Defence Infrastructure Organisation

Your Reference: EN010115

Our Reference: DIO 10053076

This letter sets out the Ministry of Defence (MOD) Safeguarding position with regard to the proposed Five Estuaries Wind Farm project. A previous letter, dated 12 July 2024, setting out the MOD position was provided to the applicant and has been accepted at the discretion of the Examining Authority. That letter was published on the Five Estuaries Offshore Wind Farm web site on 23 July 2024, with reference AS-008.

DRAWING NUMBER: **13.3**

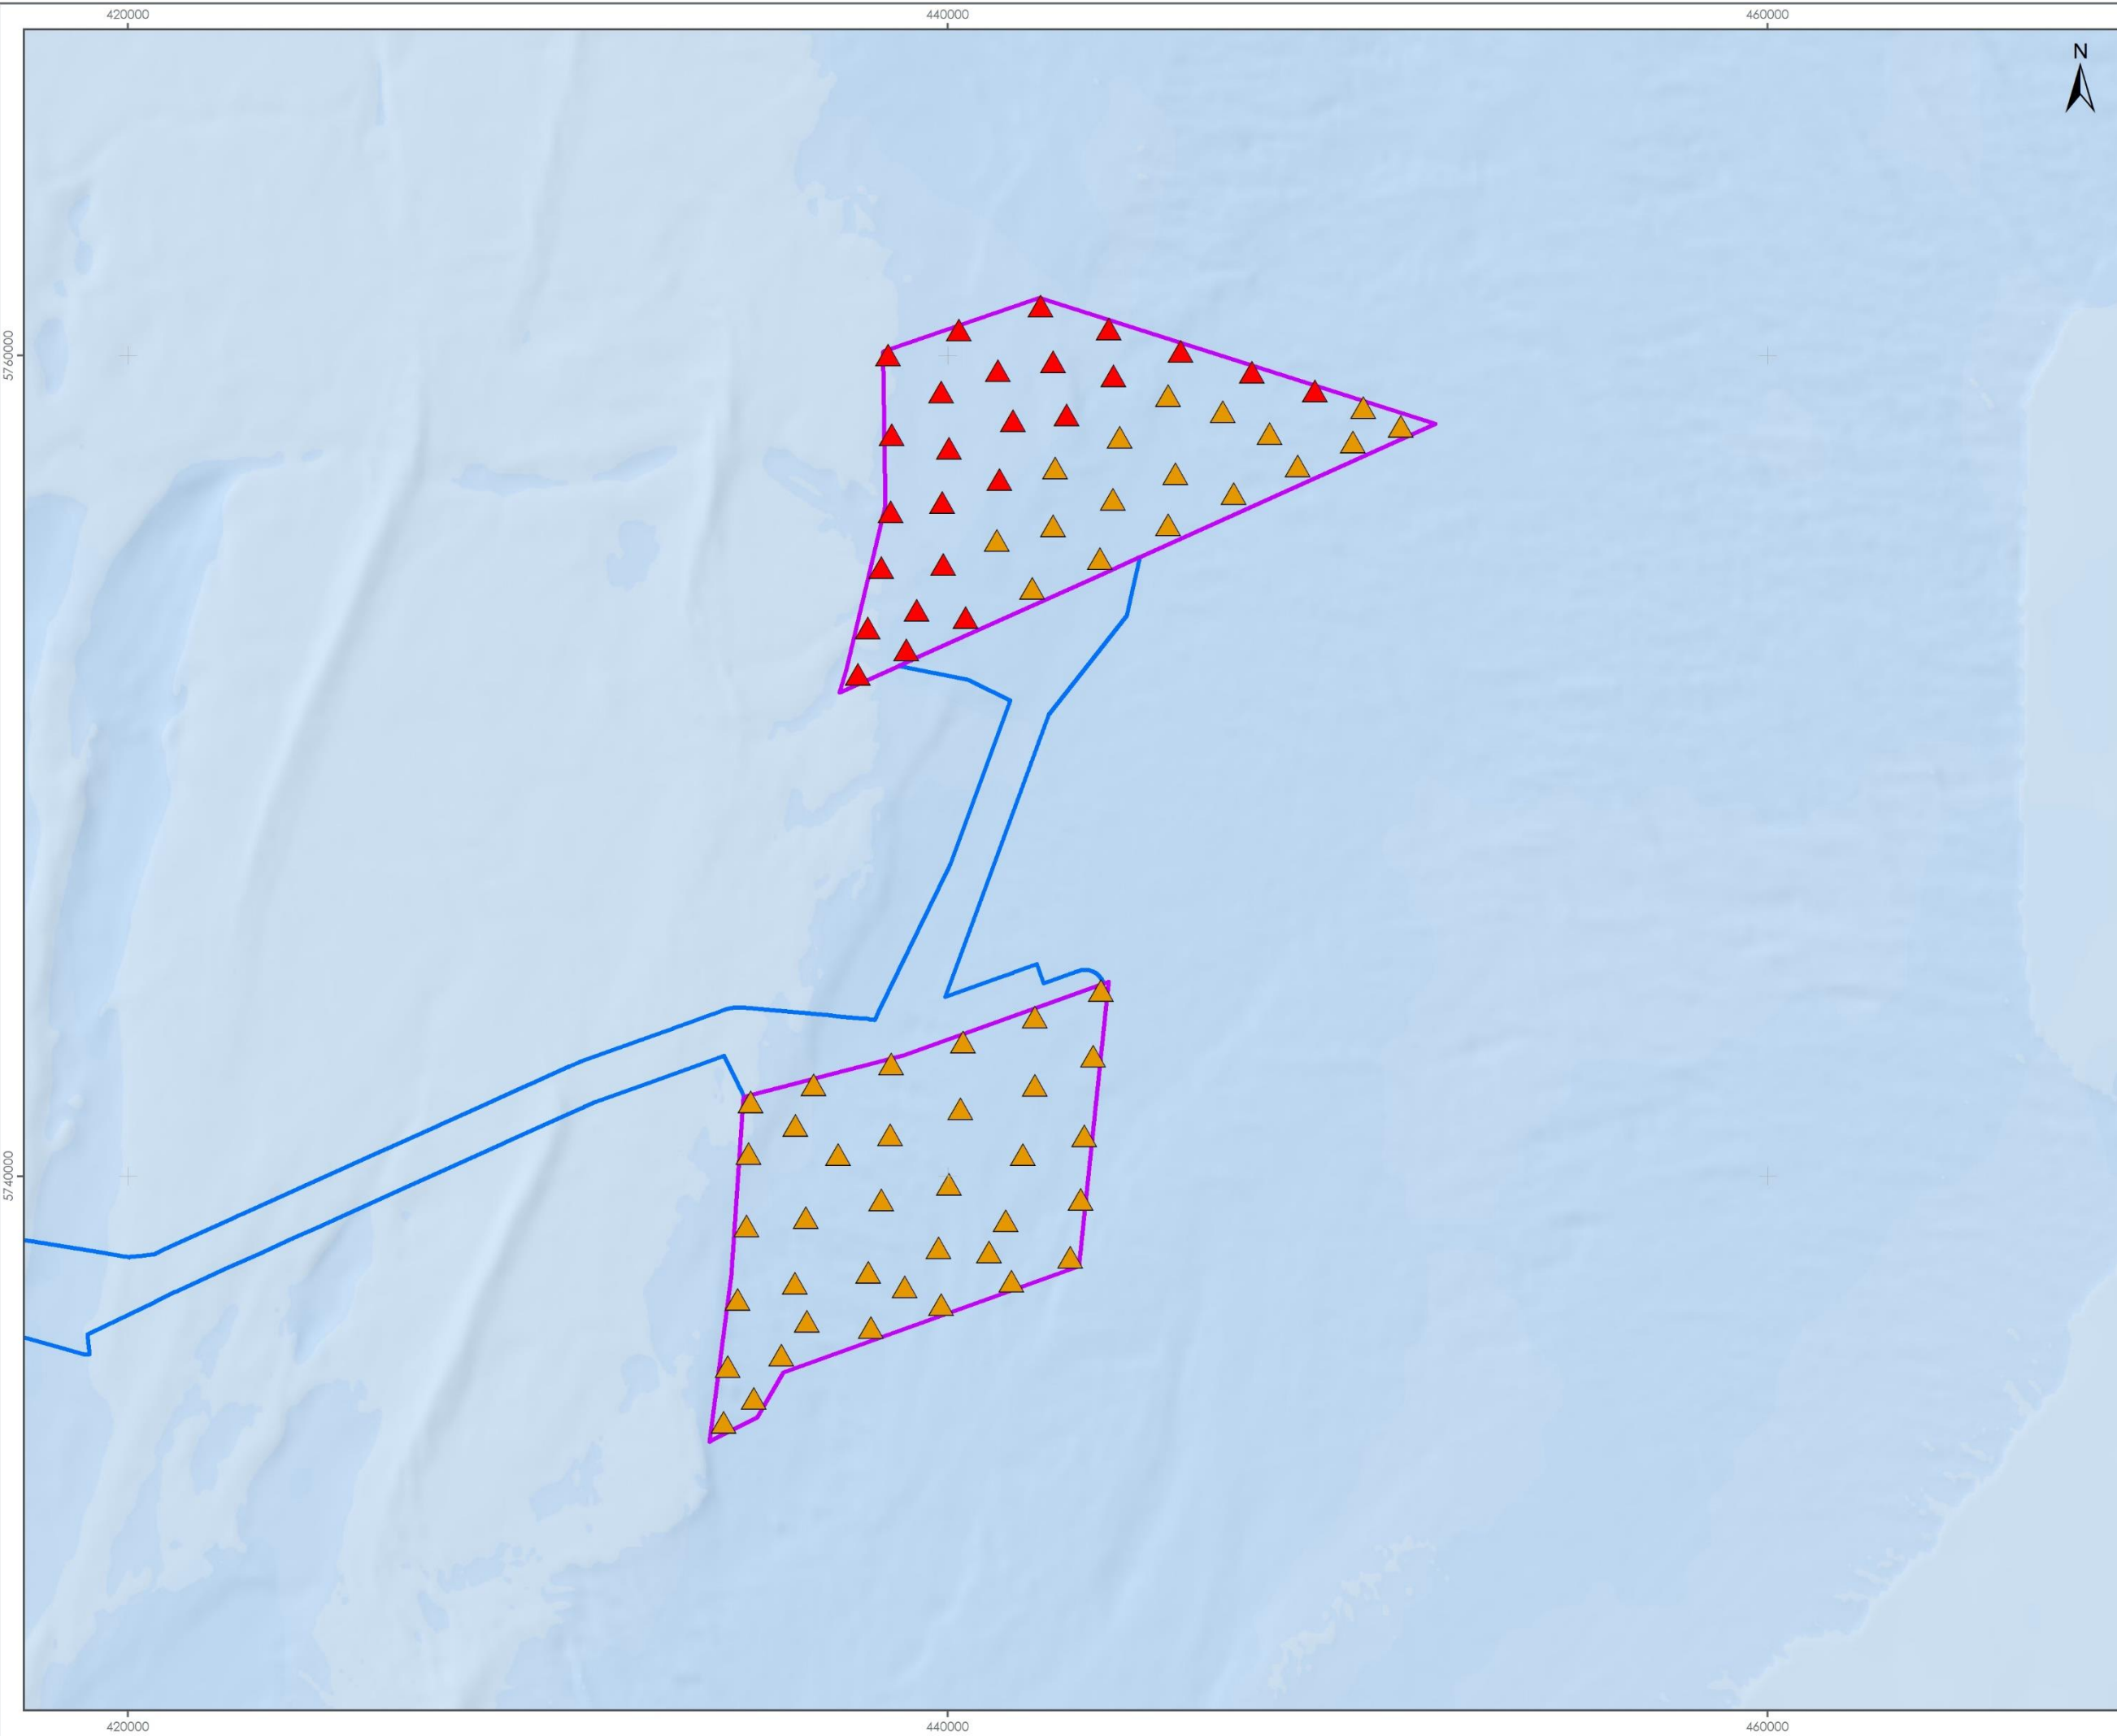
The applicant addresses the impact of the proposed development on Military and Civil Aviation through Volume 6, Part 2, Chapter 13 of the submitted Environmental Statement (Application Reference No. 6.2.13, Rev. A, dated March 2024). At paragraphs 13.4.15 and 13.4.16 the applicant identifies the potential for the development to be visible to, and detectable by Air Defence (AD) Radars deployed at Remote Radar Head (RRH) Neatishead. It should be noted that the AD Radar previously deployed at RRH Trimmingham has been redeployed at RRH Neatishead, and as such RRH Trimmingham may be omitted from assessments.

The MOD has carried out assessments based on Rochdale Envelope boundary co-ordinates provided by the applicant and accounting for a maximum blade tip height of 395m MHWS. These assessments

concluded that turbines within both the southern and northern array areas will be detectable to the AD Radar at RRH Neatishead.

Wind turbines have been shown to have detrimental effects on the operation of AD radar. These include the desensitisation of the radar in the vicinity of wind turbines, and the creation of "false" aircraft returns. The probability of the radar detecting aircraft flying over or in the locality of the turbines would be reduced, hence turbine proliferation within a specific locality can result in unacceptable degradation of the radar's operational integrity. This would reduce the RAF's ability to detect and manage aircraft in United Kingdom sovereign airspace, thereby preventing it from effectively performing its primary function of Air Defence of the United Kingdom.

This impact is acknowledged by the applicant in paragraphs 13.11.6 to 13.11.14. The impact of the turbines on the operation and capability of the AD radar at RRH Neatishead must be addressed through a suitable technical mitigation. It is the applicant's responsibility to provide a suitable technical mitigation solution to the MOD. At paragraph 13.11.14 the applicant identifies that an agreed mitigation is required.

Until such time as a mitigation for the impact on AD radar has been submitted to MOD and has been assessed as being both technically and operationally viable, the MOD must maintain an objection to the proposed wind farm development.
